From: Fiona Fitzgerald
Sent: 08 August 2014 12:07
To: Simon Davis
Subject: EG/58/14/PL

Currently there is insufficient information for me to determine this application. Please ask the applicant to address the following points:

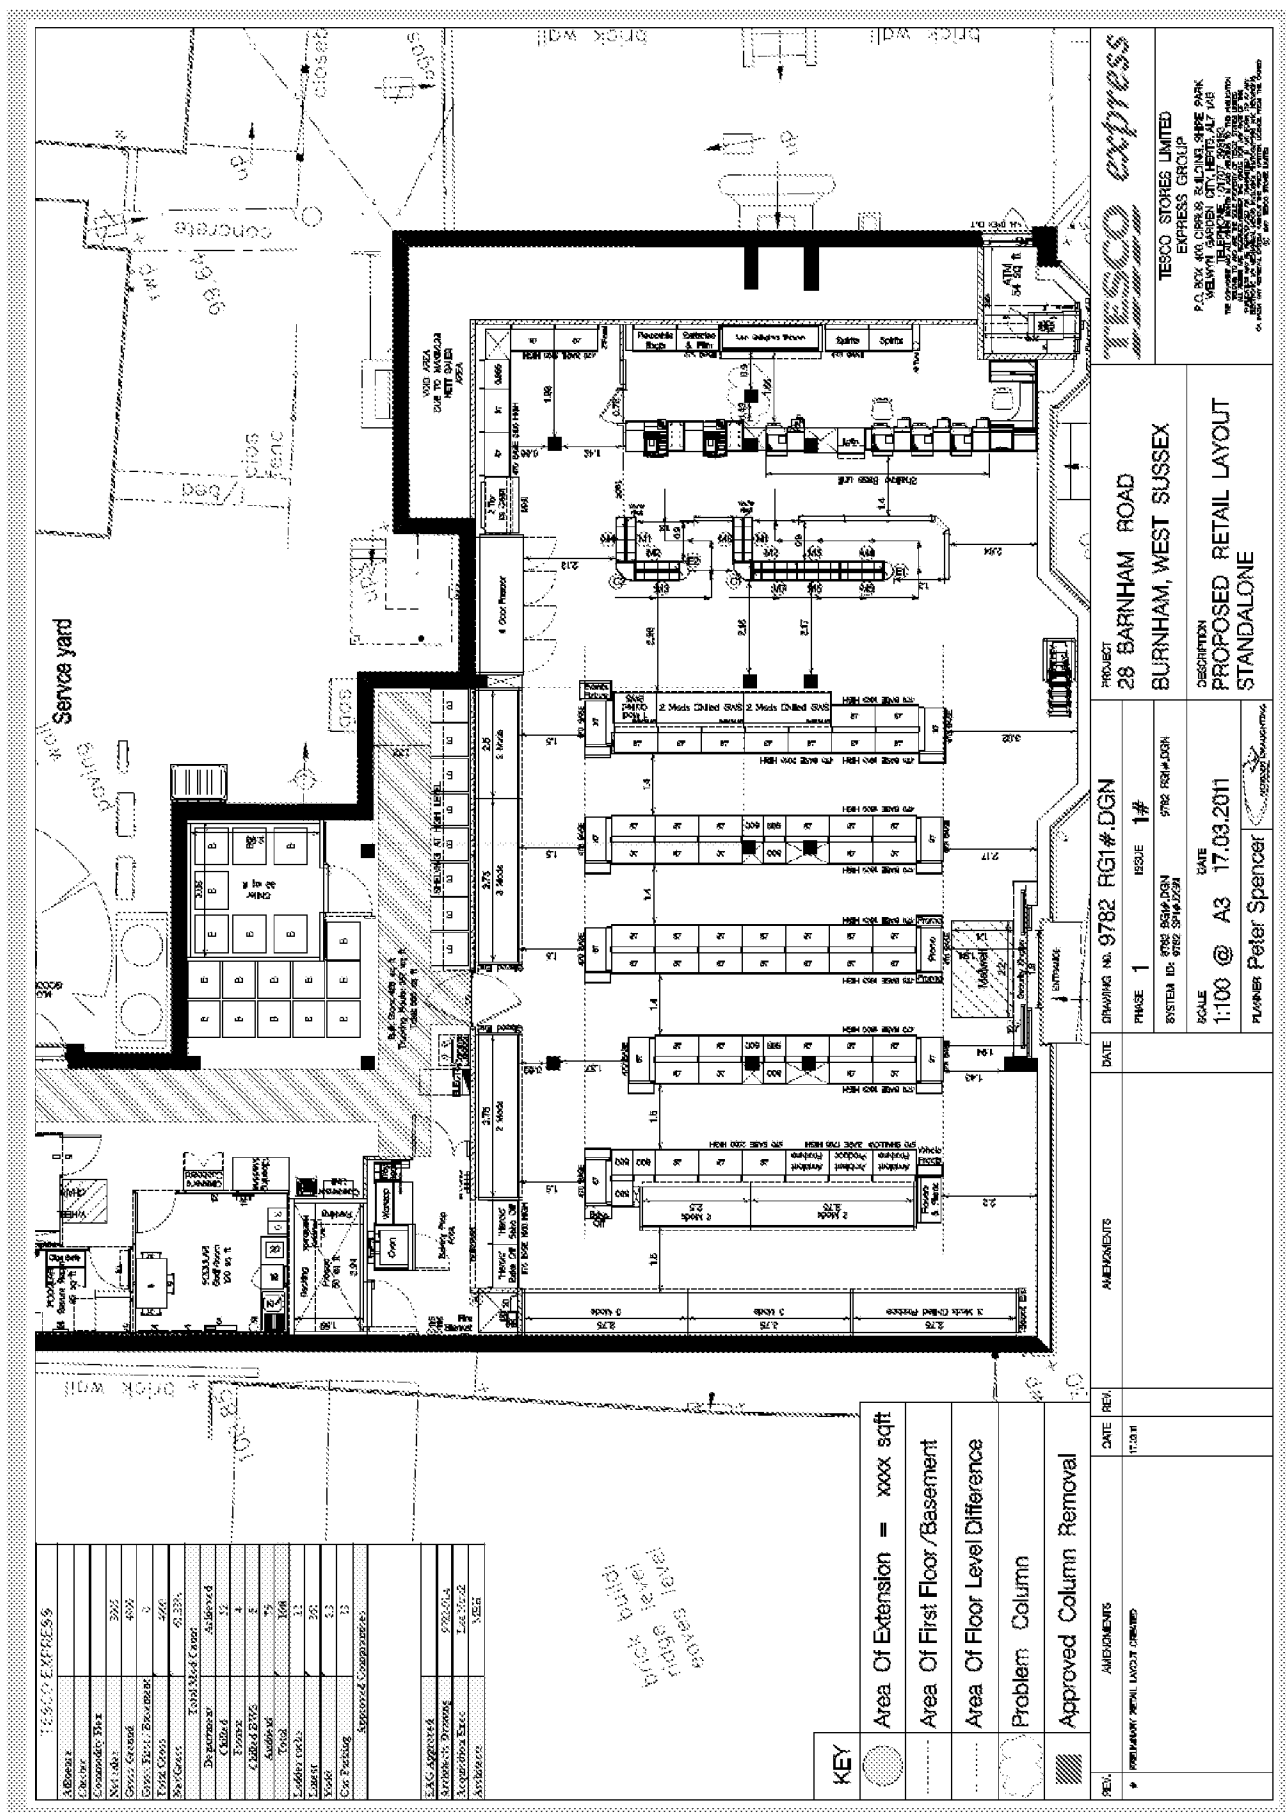
1. The acoustic report does not state specifically which property he is assuming is the closest residential property. This is alluded to in 8.2 'assessment position' but not stated. Please ask the acoustic consultant to state the address of the property for avoidance of doubt. Please also ask the acoustic consultant to confirm that they are certain that this is indeed the nearest residential property. Has he taken account of any flats above the commercial premises in this row of shops which may be affected by any potential noise?

2. In any event, the acoustic consultant appears to have assessed to the middle of the chosen residential property. In my opinion this measurement should be to the façade of the building, meaning that the acoustic consultant has added approximately 4m in his calculations. This needs to be rectified.

REAR ELEVATION-C AS PROPOSED
SCALE 1:50

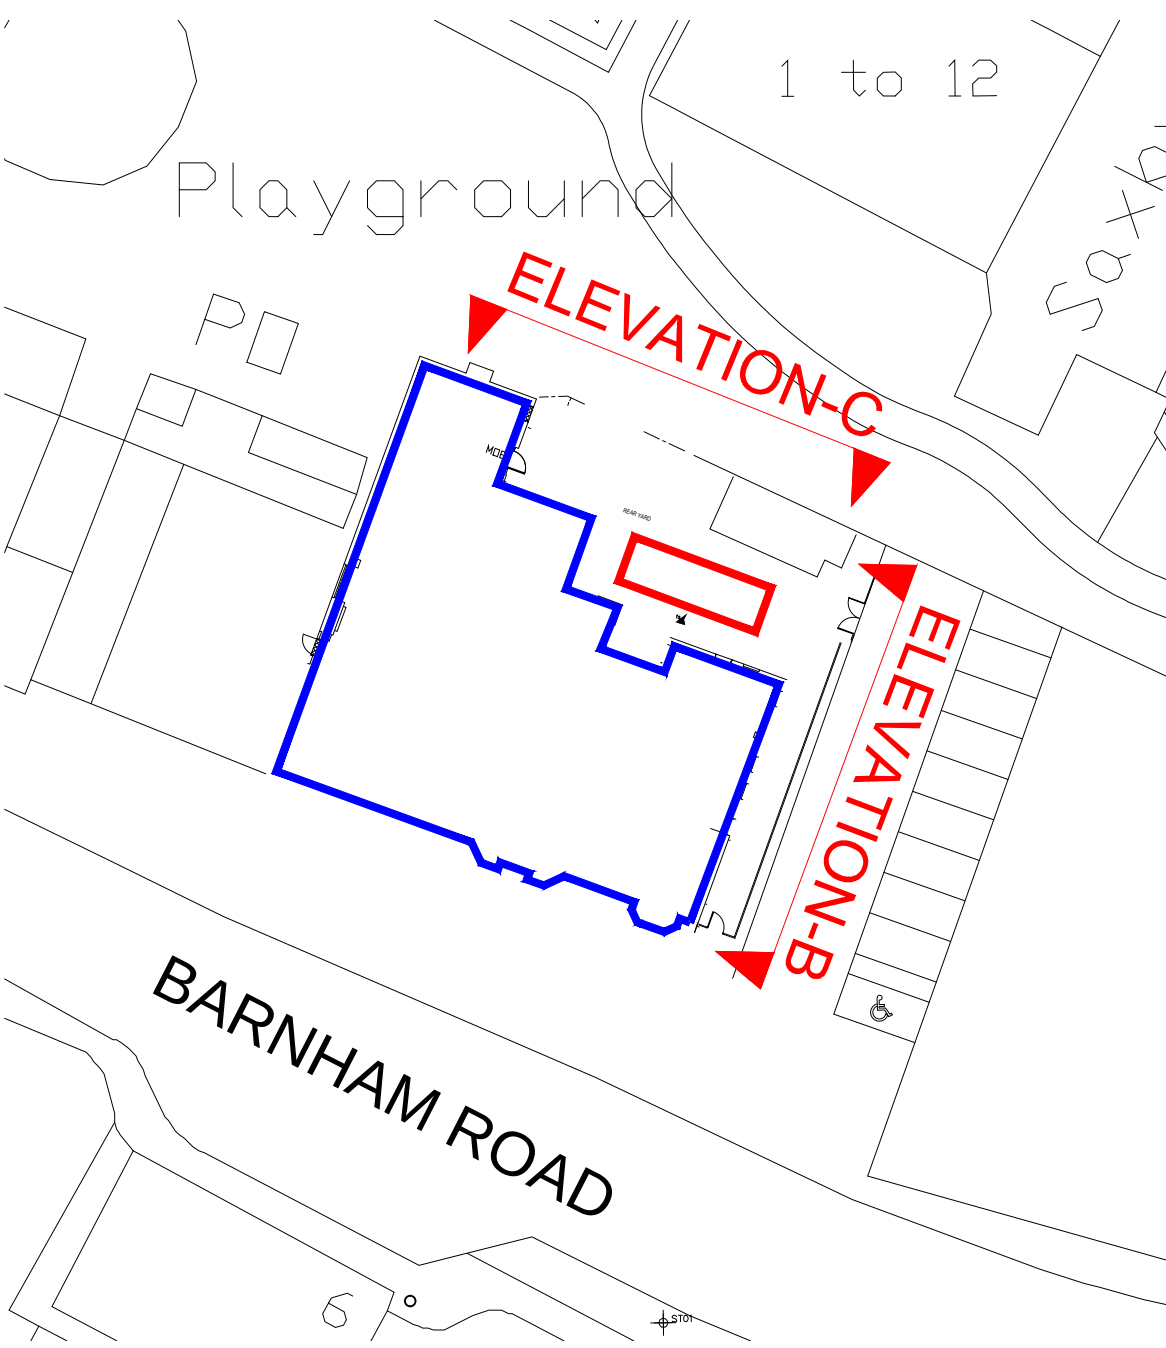
4. Each of the noise sources appears to have been assessed in isolation. The worst case scenario would surely be that they would all be working at the same time. Please ask the acoustic consultant to address this within his calculations.
